# CITY OF PORTLAND BUILDING PERMIT

**PERMIT ID:** 2013-00093

has permission to **Build a 18' x24' attached, two story garage w/ living space above** provided that the person or persons, firm or corporation accepting this permit shall comply with all of the provisions of the Statutes of Maine and of the Ordinances of the City of Portland regulating the construction, maintenance and use of the buildings and structures, and of the application on file in the department.

Proposed Use: Single Family Home	Proposed Project Description: Build a 18' x24' attached, two story garage w/ living space above
-------------------------------------	--

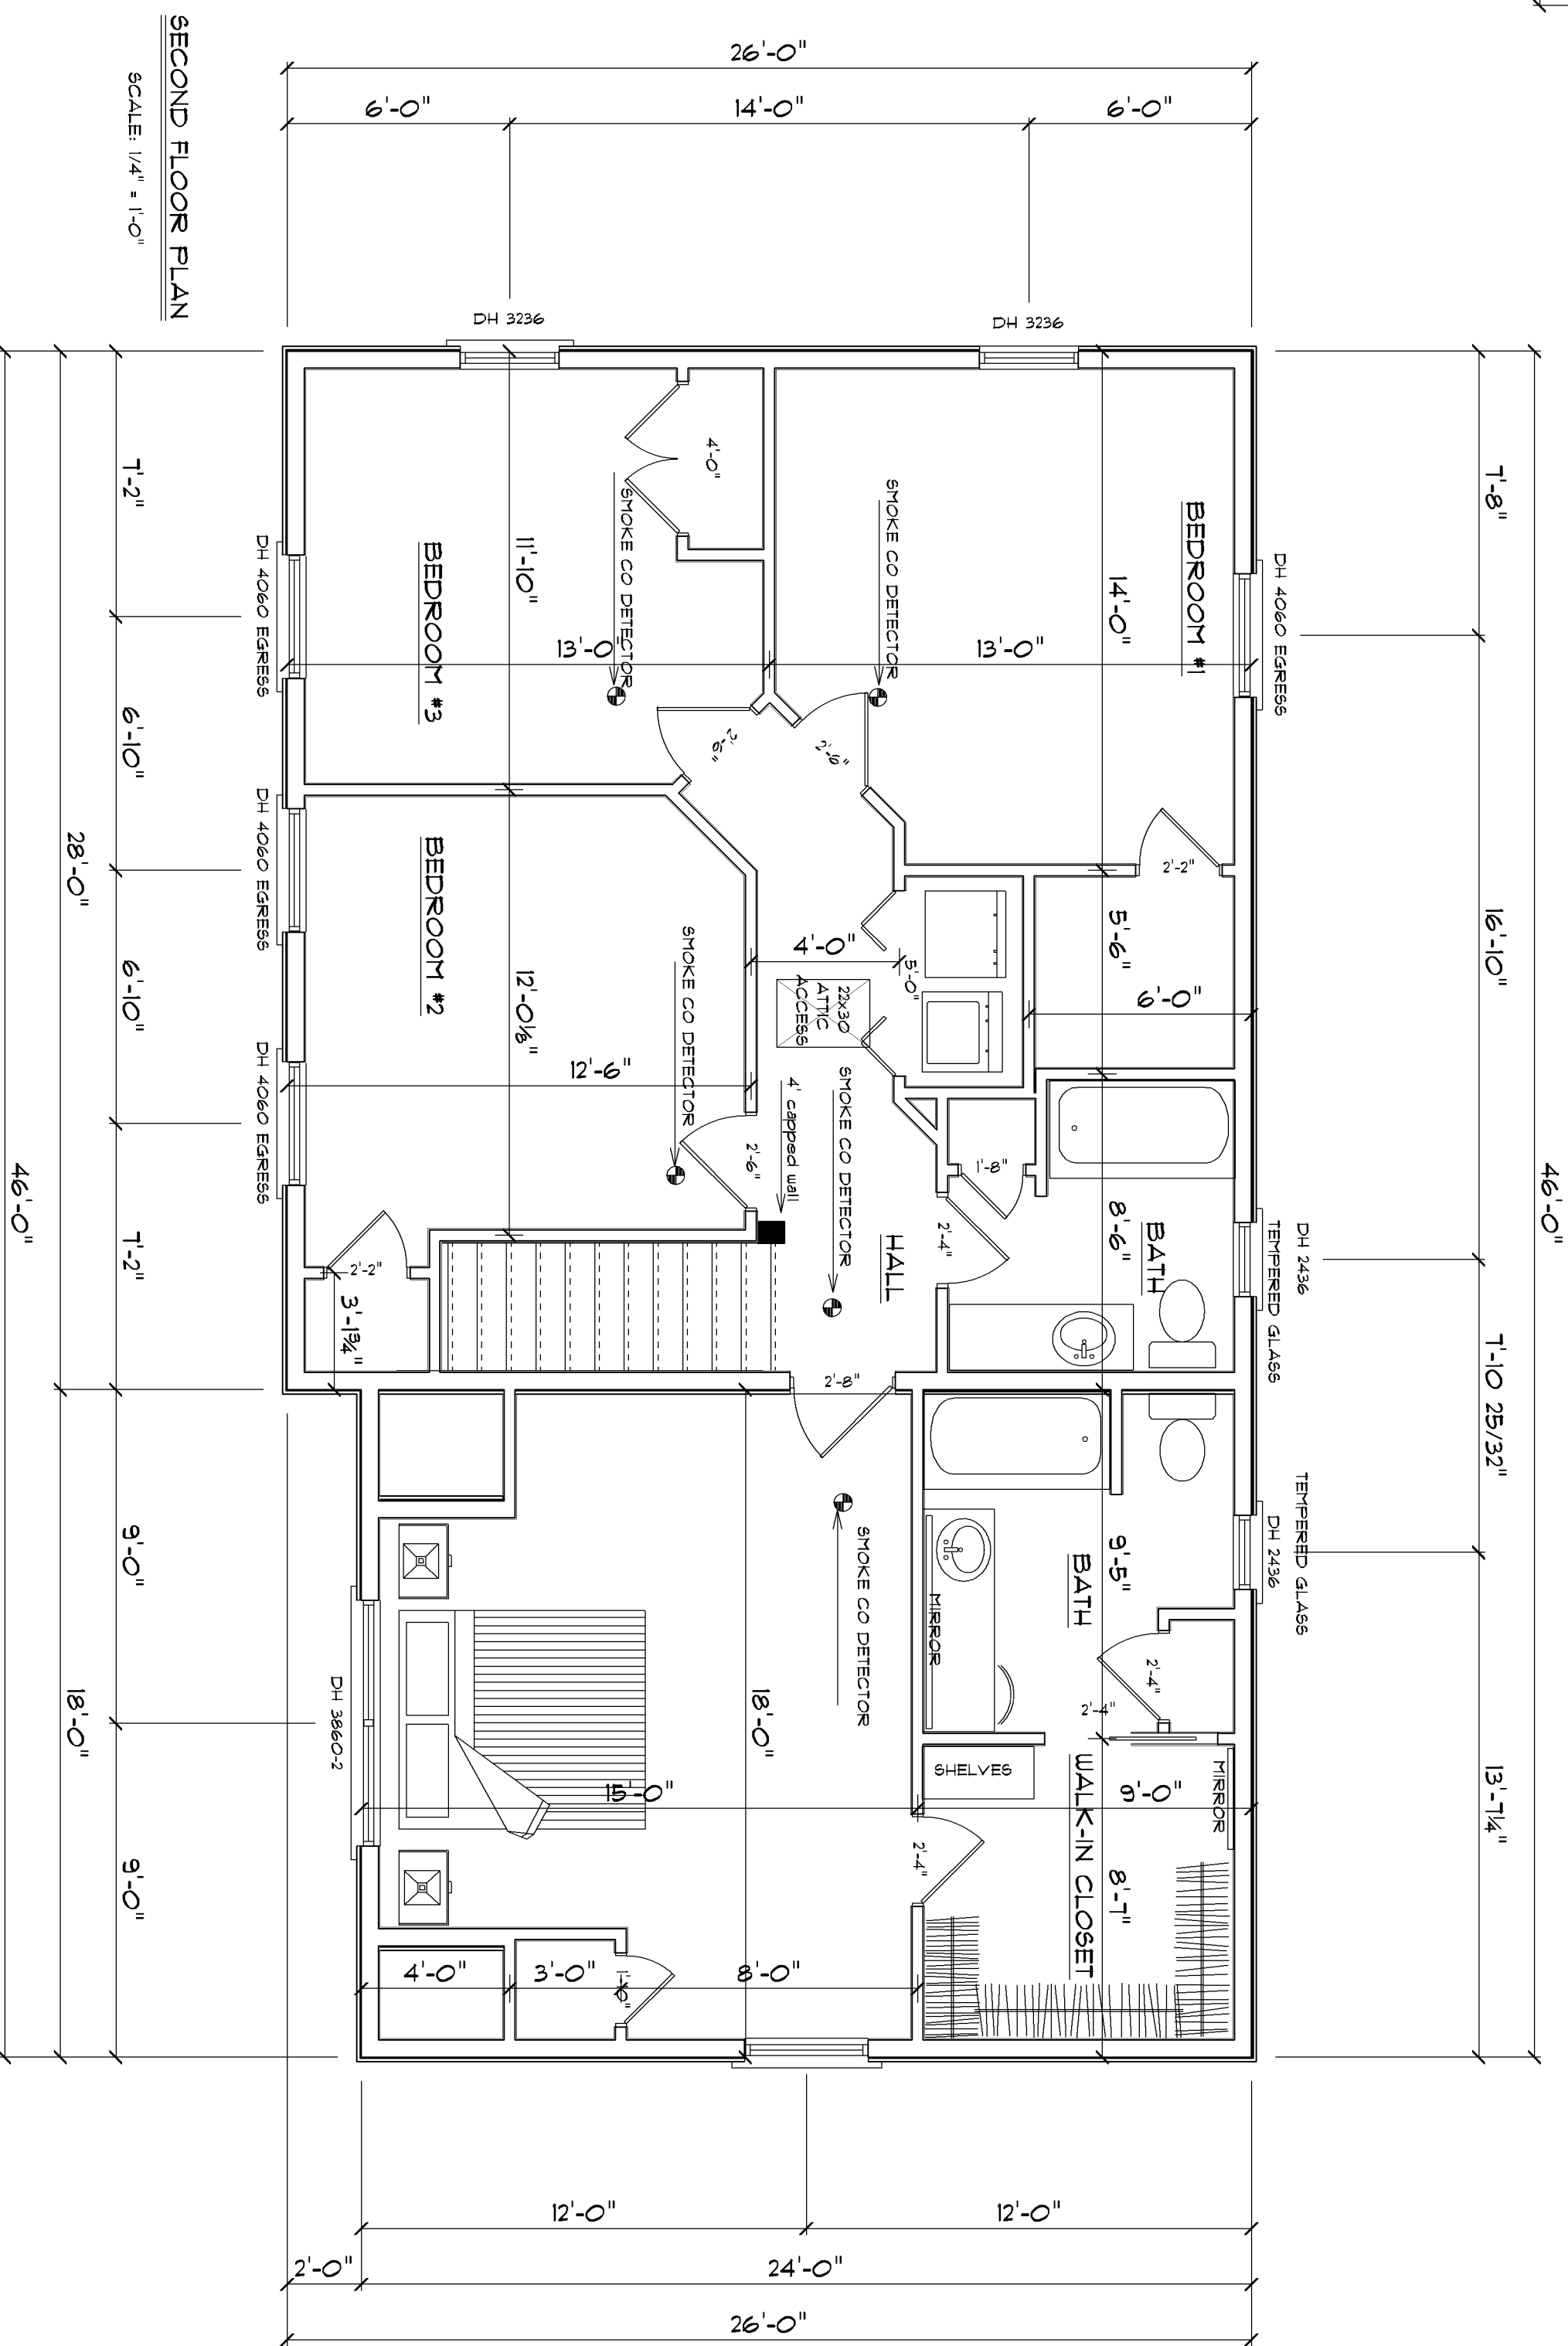
What about the door detail from the basement to the exterior? Are the roof rafters 16 inches on center and what is the headroom in the bathroom section at least 6'-8" in front of each fixture? Are you applying 1/2" Gypsum to the walls, and 5/8" Type X gypsum to the ceiling of the garage, underneath the habitable space?

Door detail attached. Rafter spacing indicated at 16' OC, Headroom noted as minimum 6'8" but not on plan. All living space below/abutting garage is fire rated sheetrock minimum with minimum 5/8 TYPE X Gypsum and other walls noted as 1/2" Gypsum. I want to dig in the morning. Is this satisfactory? Let me know if you need additional data. I apologize I forgot about the doors/stairway.
